City of Portland, Maine - Building or Use Permit Application
 389 Congress Street, 04101 Tel: (207) 874-8703, Fax: (207) 874-8716

Permit No: 09-0907	Issue Date:	CBL: 296 C012001
------------------------------	--------------------	----------------------------

Location of Construction: 204 Hicks St	Owner Name: MOUNT SINAI CEMETERY ASSOC	Owner Address: 185 HICKS ST	Phone:
Business Name:	Contractor Name: W A One Inc.	Contractor Address: PO Box 10127 Portland	Phone 2077734988
Lessee/Buyer's Name	Phone:	Permit Type: Duplex	Zone:

Past Use: Vacant Land	Proposed Use: Duplex - construct a 28' x 32 Duplex - 896 sq ft w/2 Bedrooms per unit	Permit Fee: \$1,345.00	Cost of Work: \$125,000.00	CEO District: 5
Proposed Project Description: construct a 28' x 32 Duplex - 896 sq ft w/2 Bedrooms per unit		FIRE DEPT: <input type="checkbox"/> Approved <input type="checkbox"/> Denied	INSPECTION: Use Group: Type	
		Signature:	Signature:	
PEDESTRIAN ACTIVITIES DISTRICT (P.A.D.)				
Action <input type="checkbox"/> Approved <input type="checkbox"/> Approved w/Condition <input type="checkbox"/> Denied				
		Signature:	Date:

PARTY WALL DETAIL 1 1/2" = 1'-0" UL # U305 SIM

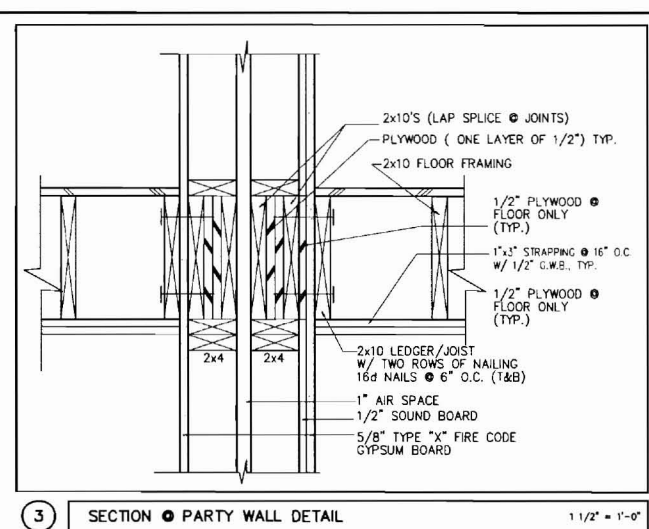
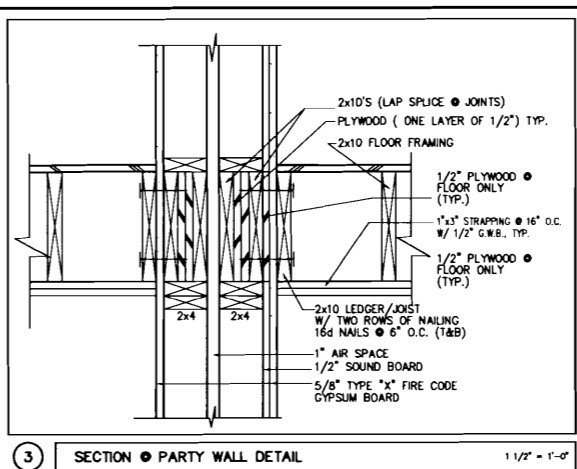
- 1) All floors and walls that separate dwelling units or dwelling units and common areas are required to meet a 1 hour fire rated assembly and sound transmission rating of 45 STC.

- 2) All penetrations between dwelling units and dwelling units and common areas shall be protected with approved firestop materials, and recessed lighting/vent fixtures shall not reduce the (1 hour) required rating per Sec. 712 of IBC
